**From:** [Downes, Scott G \(DFW\)](#)  
**To:** [Rachael Stevie \(CD\)](#)  
**Cc:** [Richard Pierson](#); [Torrey, Elizabeth M \(DFW\)](#); [Jeremy Johnston](#)  
**Subject:** RE: SE-21-00014 Pierson - Notice of Application  
**Date:** Monday, August 2, 2021 10:25:08 AM  
**Attachments:** [image001.png](#)

Thank you for the opportunity to provide comments on this Shoreline Exemption for SE-21-00014 Pierson. Washington Department of Fish and Wildlife (WDFW) has been in contact with the applicant during their project proposal development and we wish to share some of the relevant details that we have provided to the applicant.

# BARB CONSTRUCTION DETAIL

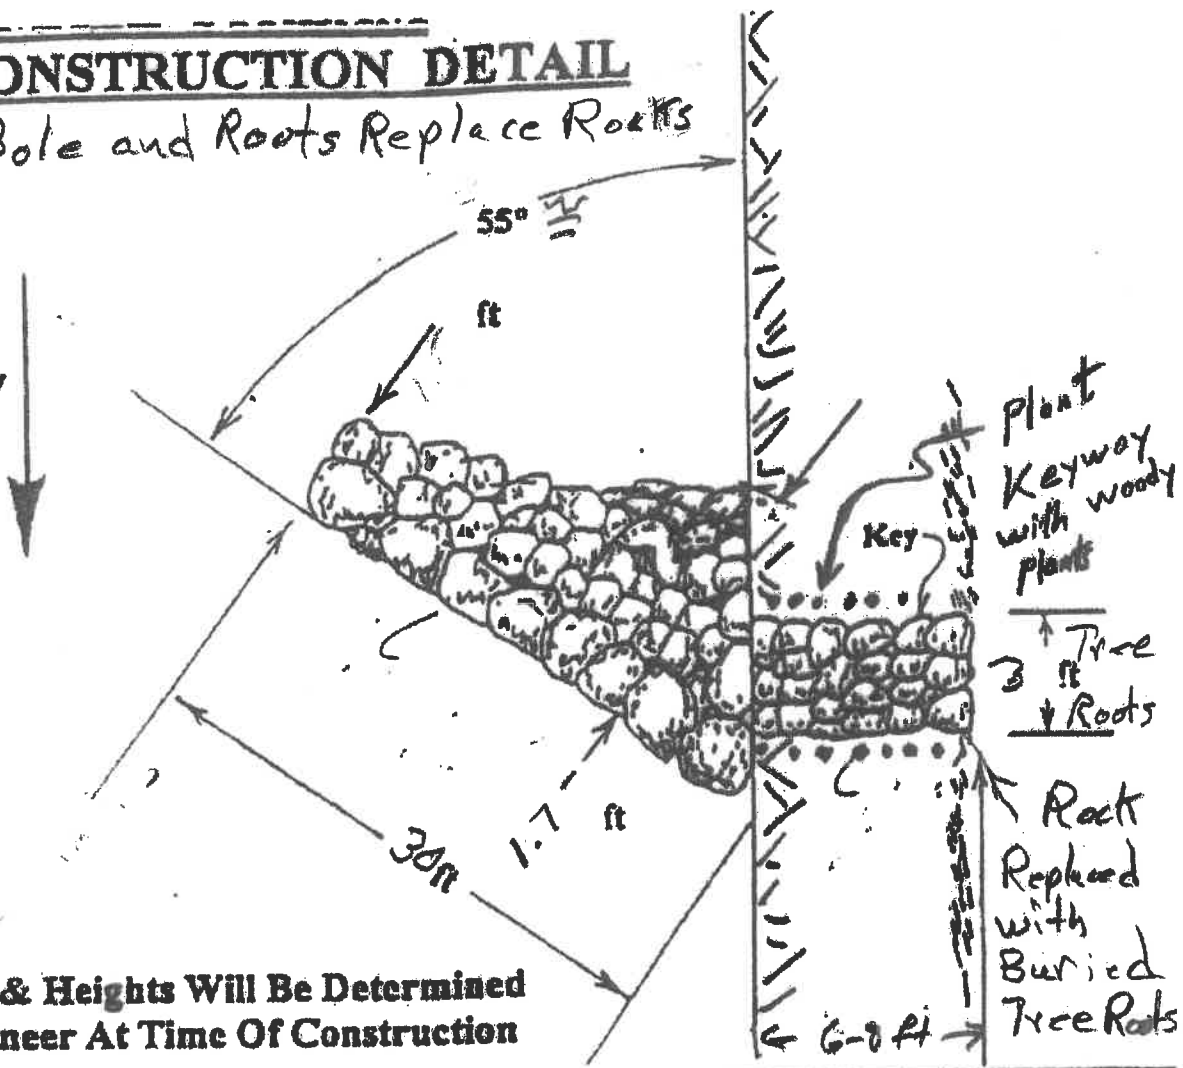
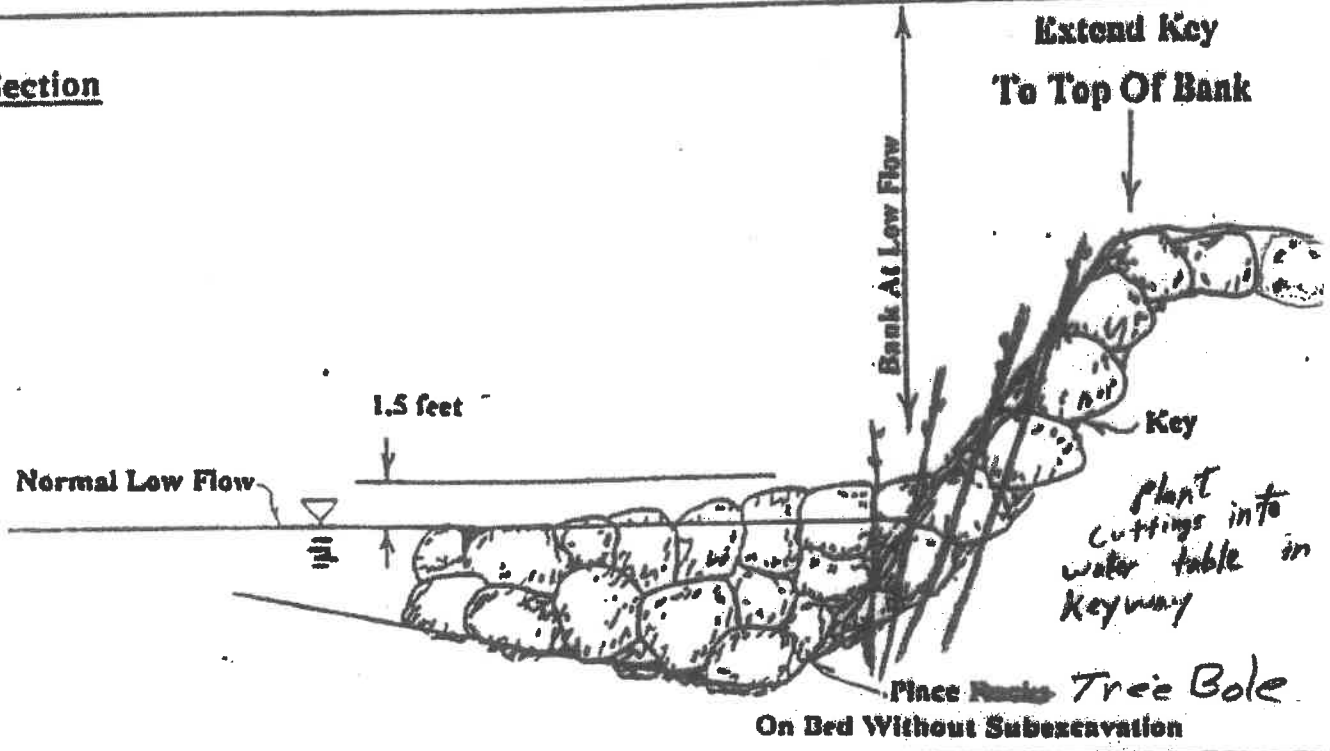
1. A Hydraulic Project Approval (HPA) permit from WDFW would be needed for this work.
2. Bioengineering consisting of more stream friendly materials such as wood and plants is preferred over armoring solely with rock.
3. The project location has complexity and Gold Creek is dynamic at this location. While WDFW cannot require engineering through the HPA permit process, engineering is encouraged to ensure there are no unintended consequences as a result of the design at the site.
4. There are long-term restoration plans for this reach of Gold Creek. Barbs are considered a short-term temporary fix for shoreline erosion. This bank protection work should be in support of the long-term restoration plans which should benefit both restoration of Gold Creek and the bank stability of streamside residential structures.
